DECISION DELEGATED TO HEAD OF PLANNING

Application No: H16-0662-26 **Applicant:** Stamford Properties Development Ltd

Proposal: Redevelopment, demolition and extension of vacant former Regent Bingo Club to include 41 residential units, comprising one, two and three bedroom apartments. The scheme also incorporates 298 sq m of flexible commercial floorspace within Use Class E (Commercial, Business & Service), together with dedicated residents external amenity space. The development will utilise existing vehicular and pedestrian access routes, providing parking areas to the rear with 28 parking bays and cycle parking, servicing arrangements and associated works.

Location: Former Regent Bingo Club Westlode Street Spalding

North Elevation
NTS

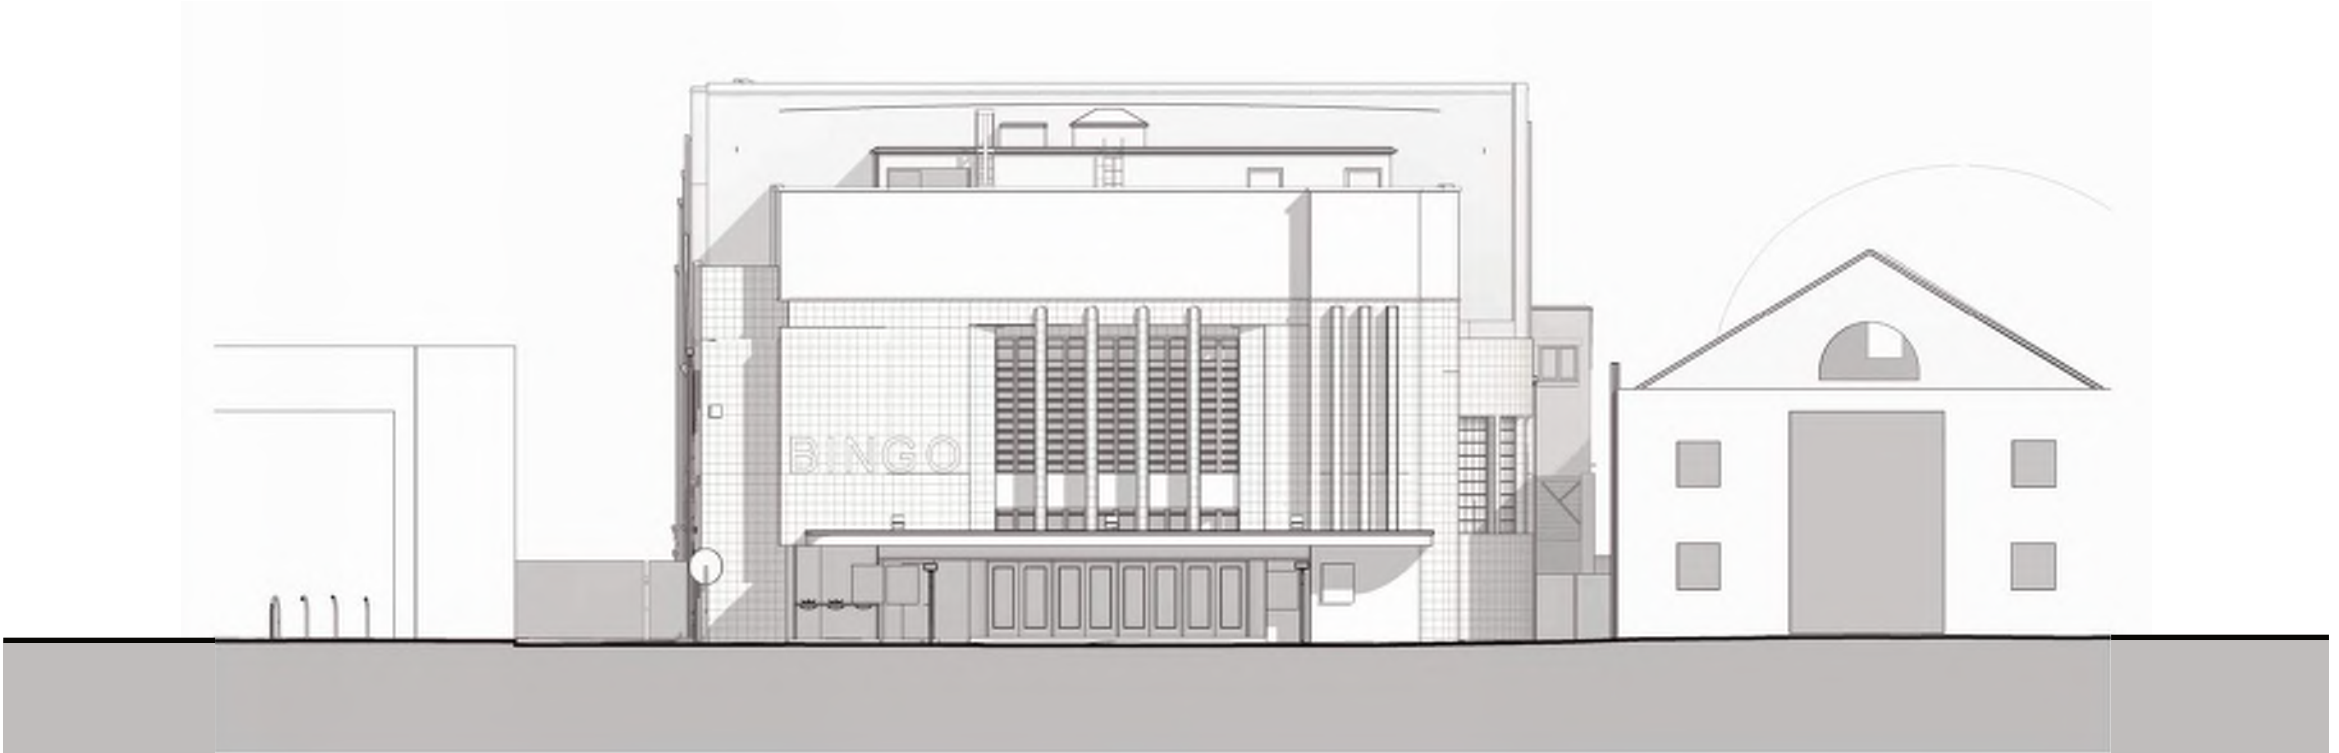
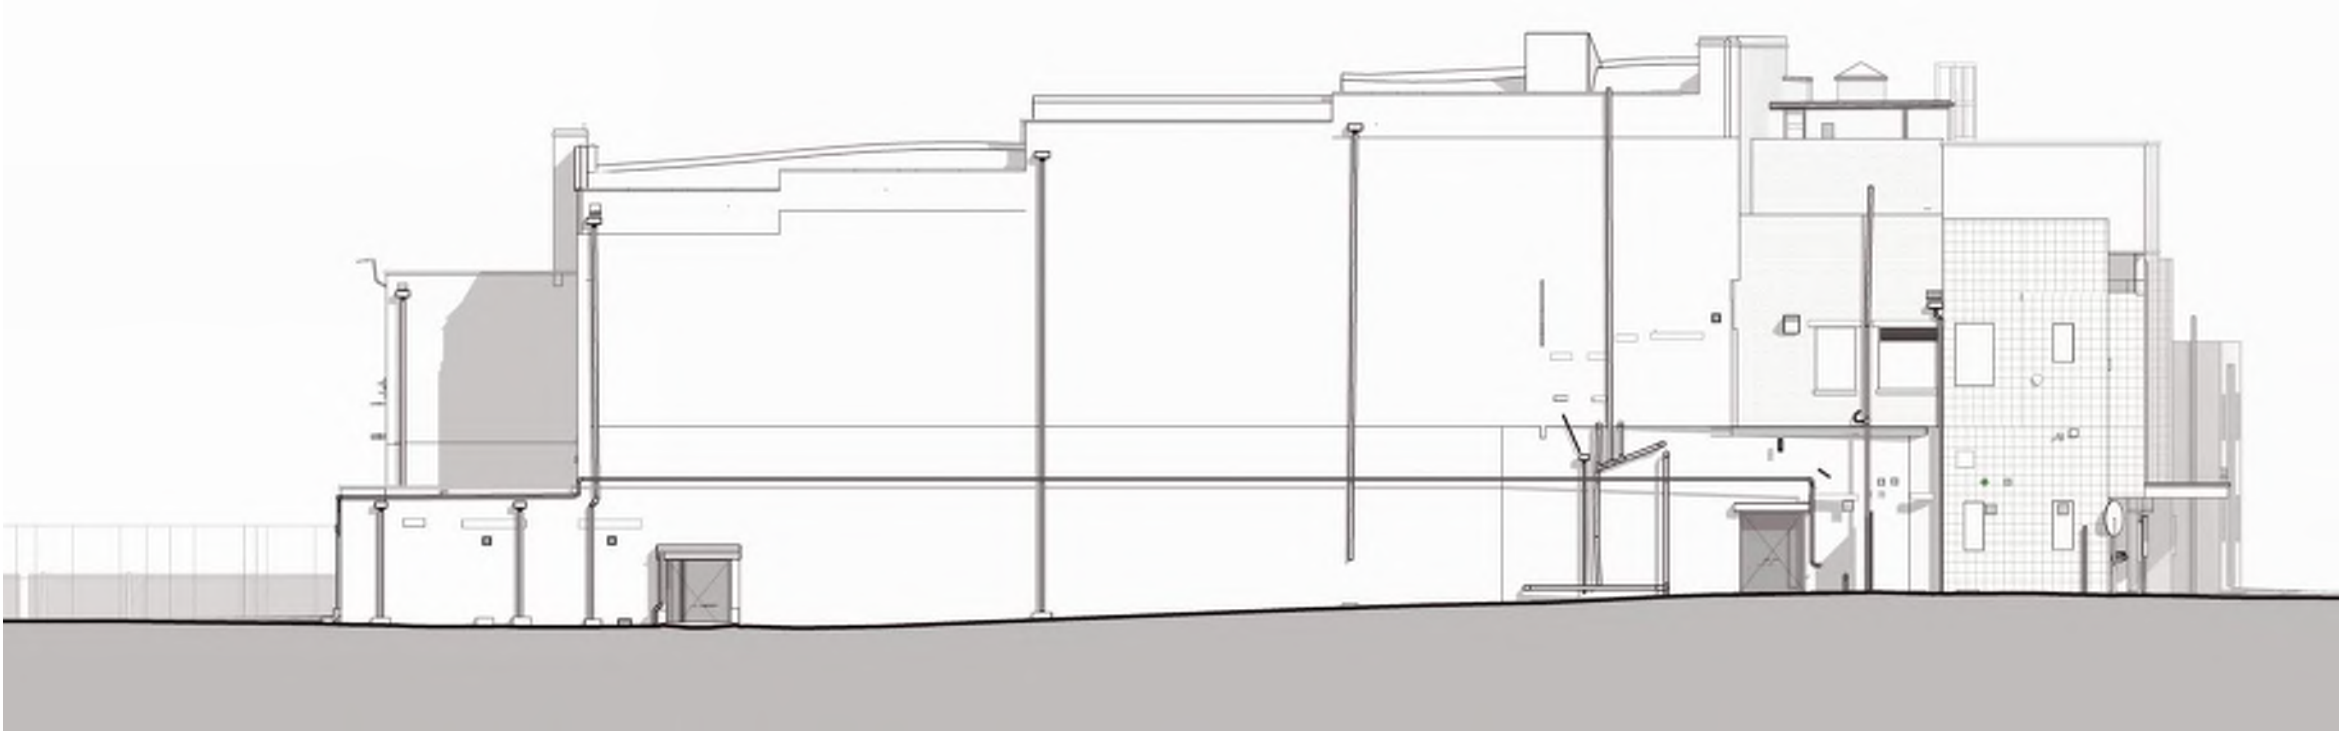
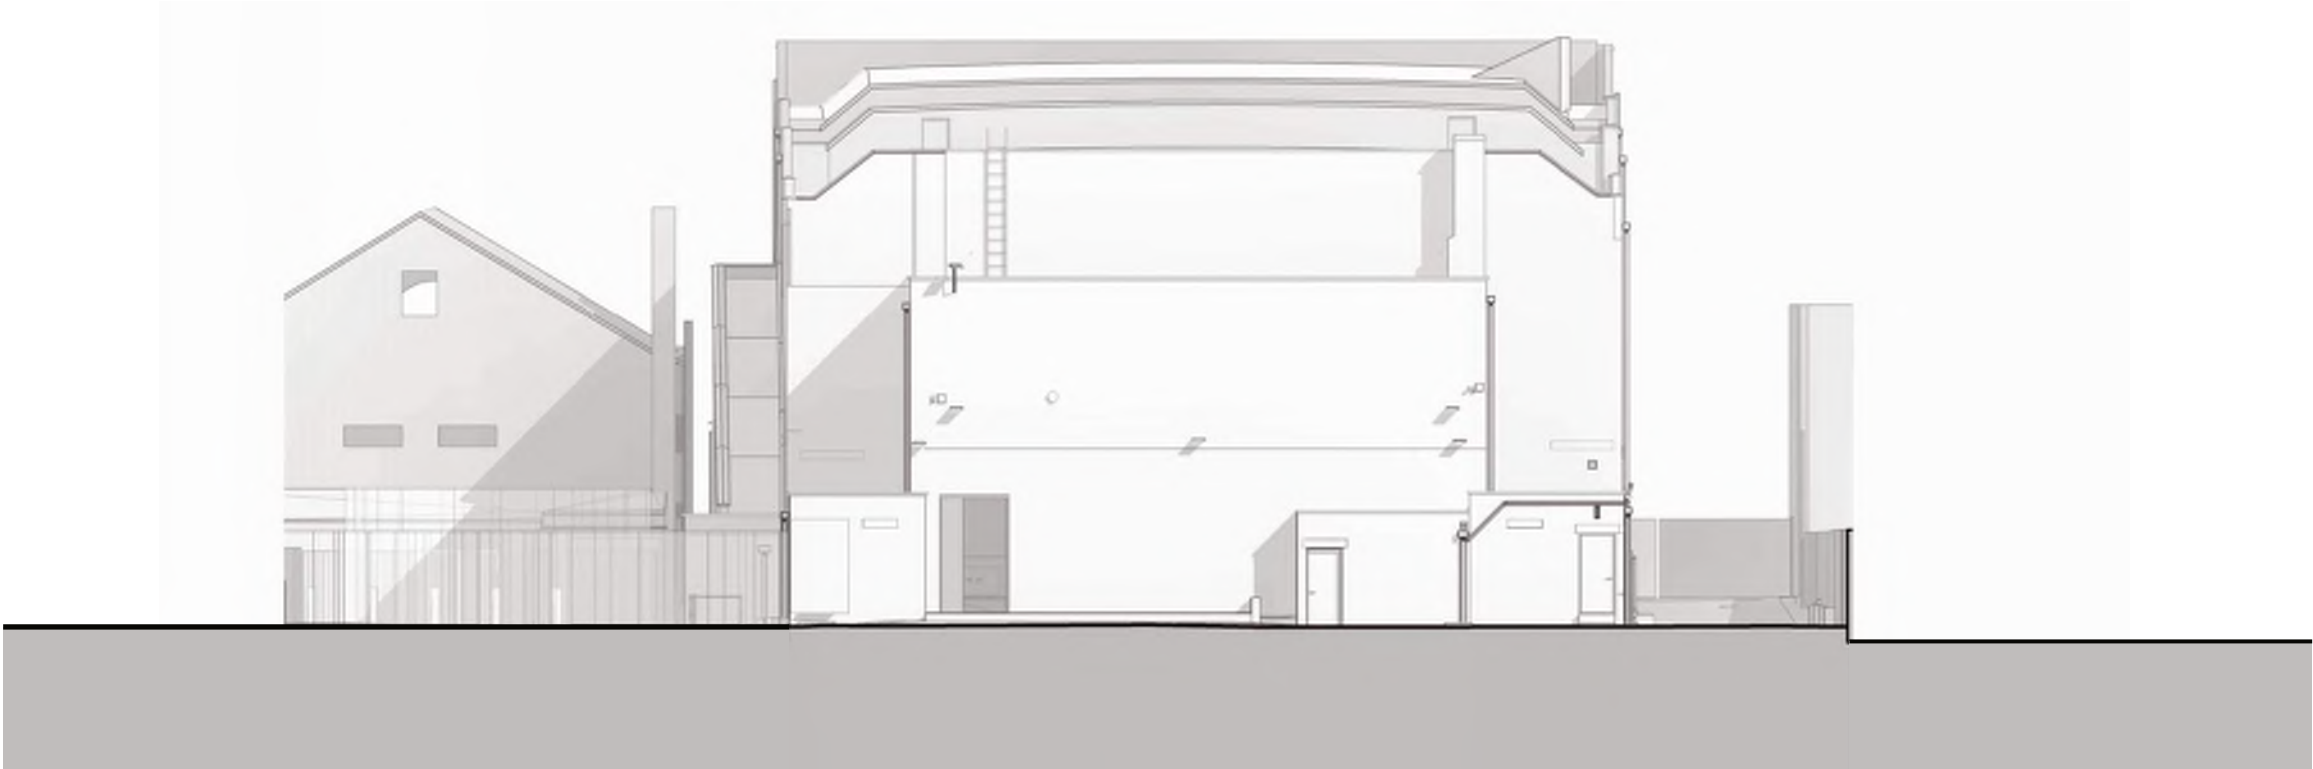
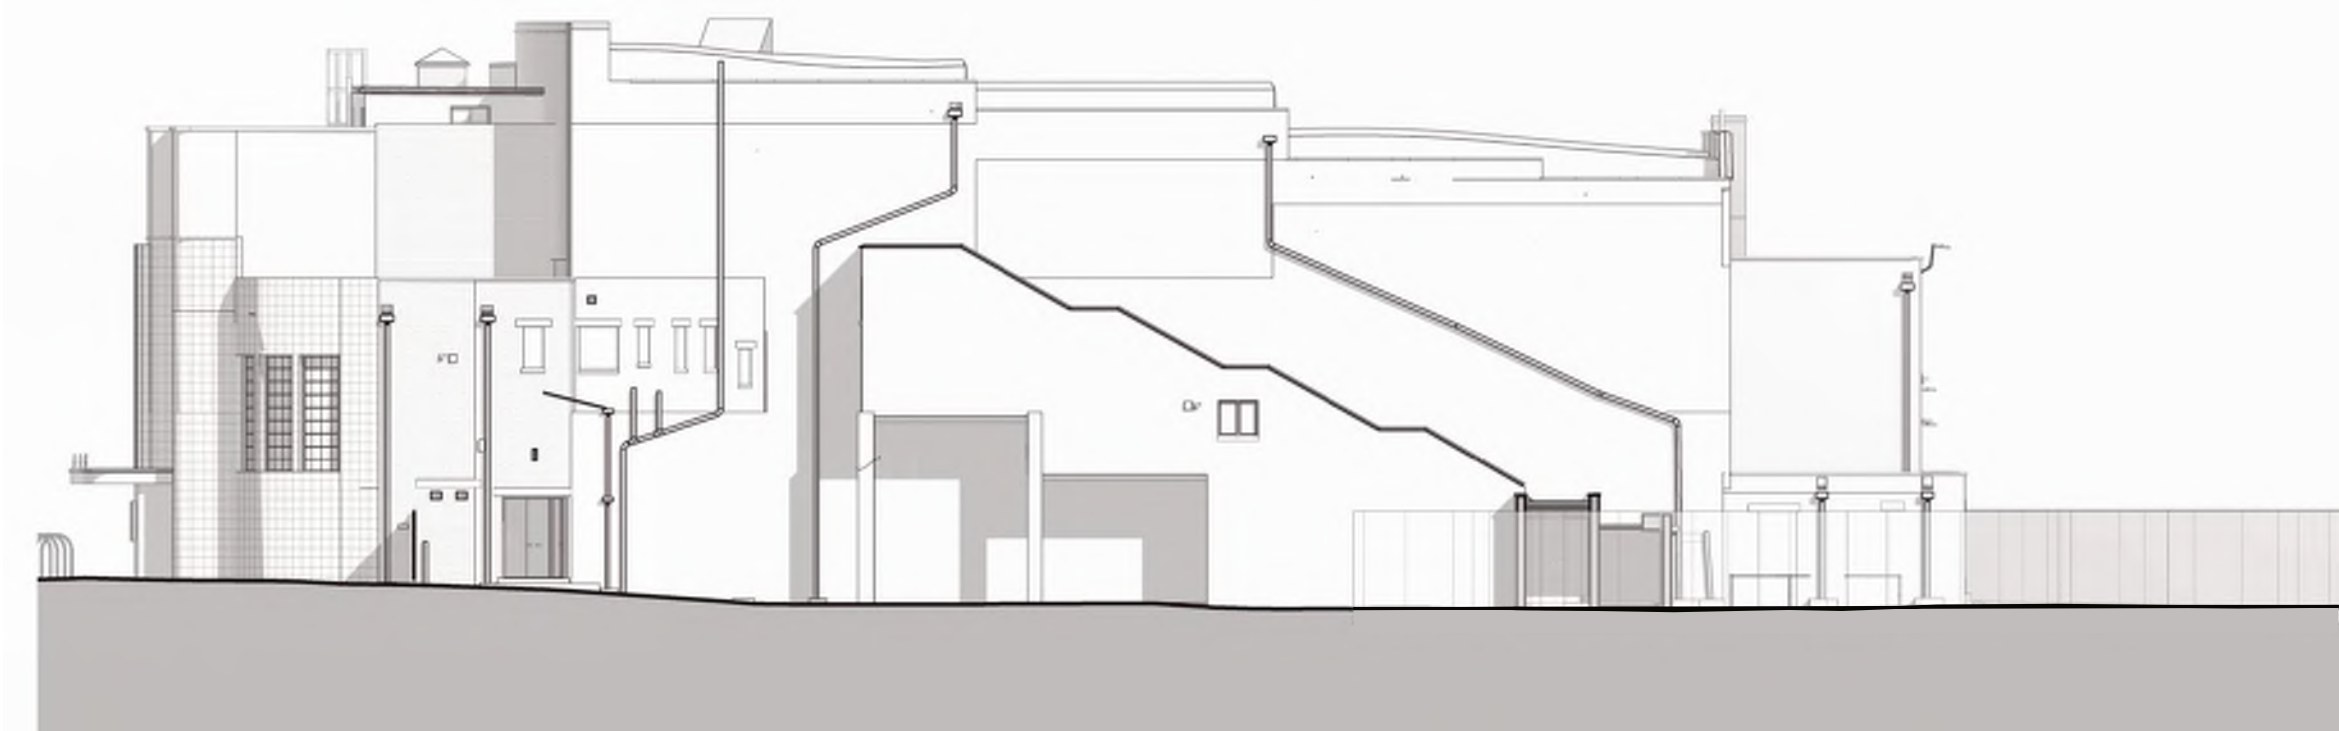
The enlarged residential block would rise prominently behind the Art Deco frontage. Its broad elevations, repeated windows and continuous parapet would draw attention away from the frontage and make the new accommodation the dominant part of the building. The setback would provide some separation, but would not prevent the upper structure from appearing overbearing.

The Conservation Officer considers that the proposal would "entirely dwarf the significant art deco frontage". This concern is accepted. Although the frontage would remain physically intact, it would be visually overwhelmed by the development behind it. Its distinctive form and detailing would become subordinate to the much larger residential block, reducing its architectural presence within the street scene. This would harm the significance of the non-designated heritage asset.

The Conservation Officer describes the resulting building as "visually unwieldy and unduly prominent". The proposed windows would break up the elevations, but would not sufficiently reduce the impression of a large, continuous block. The development would dominate the local roofscape and weaken the contribution made by the Art Deco frontage to this part of the conservation area. It would therefore fail to respect local distinctiveness in height, massing, scale and form, contrary to Policy 29(B).

Proposed Vehicle Parking

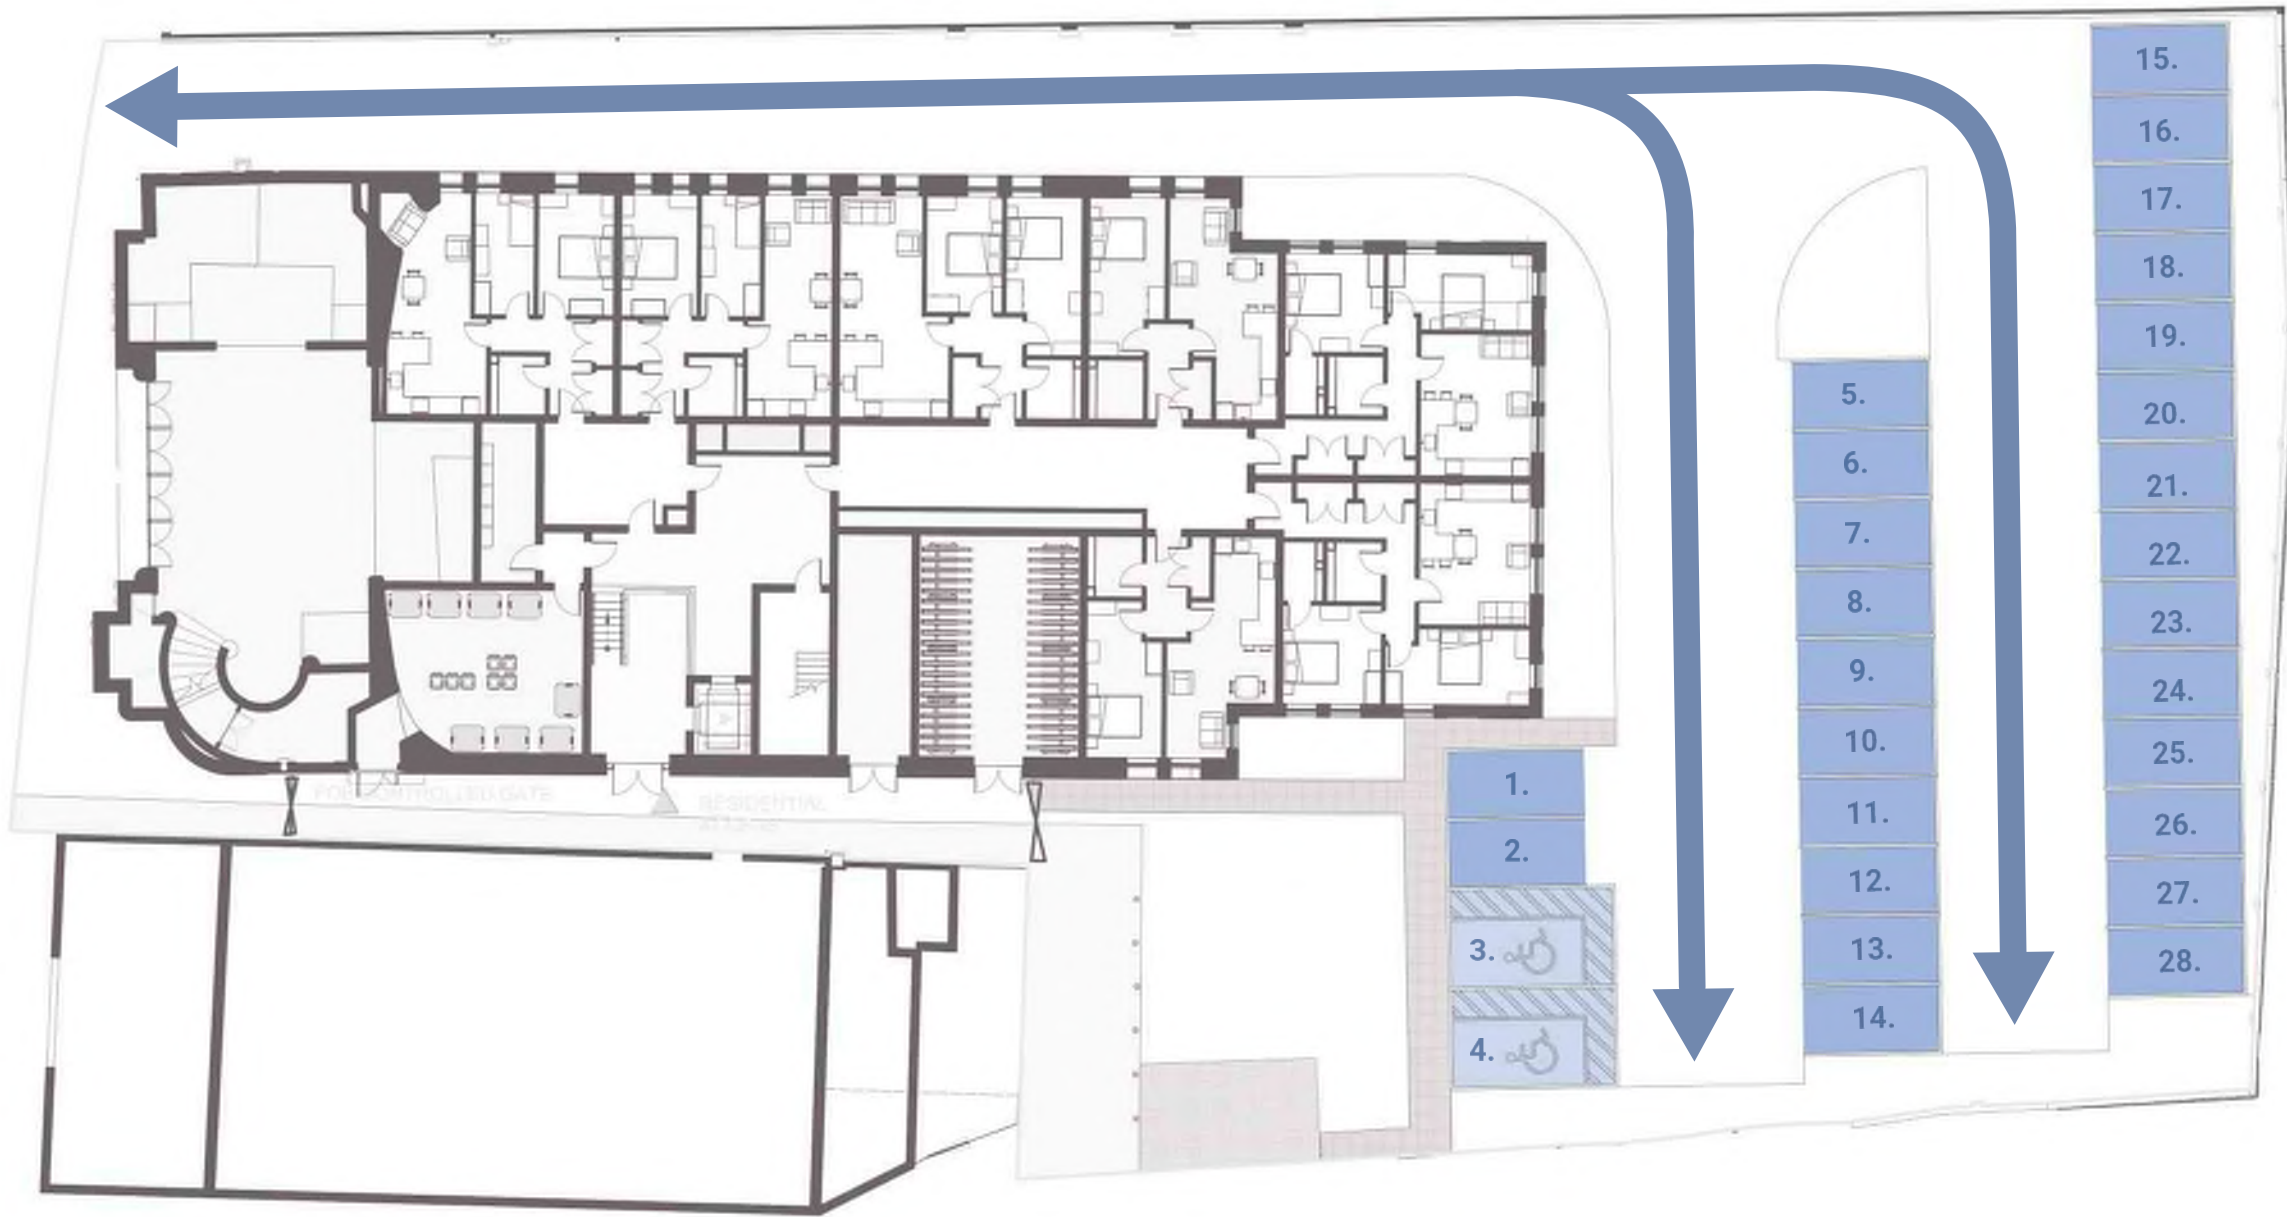
The Highway Authority welcomes the cycle provision but considers that this alone does not justify the shortfall against the Local Plan parking standards. It has requested a Transport Statement to demonstrate that the proposed parking provision would be appropriate and would not cause harmful overspill parking or adverse effects on the surrounding highway network. Its formal recommendation is deferral pending further information.

No Transport Statement or Transport Assessment has been submitted to demonstrate the likely parking demand associated with the apartments and commercial accommodation. The application also does not adequately explain how parking would be allocated or managed. The Highway Authority specifically seeks clarification of whether spaces would be allocated to individual apartments or remain unallocated, noting the potential for additional movements from residents searching for available spaces.

The Highway Authority raises a further concern about the operation of the existing access. It states that the access "appears constrained and may not provide sufficient width to accommodate two-way vehicle movements". It therefore requests assessment demonstrating that vehicles would not need to wait on Westlode Street while other vehicles enter or leave the site, to the detriment of highway safety.
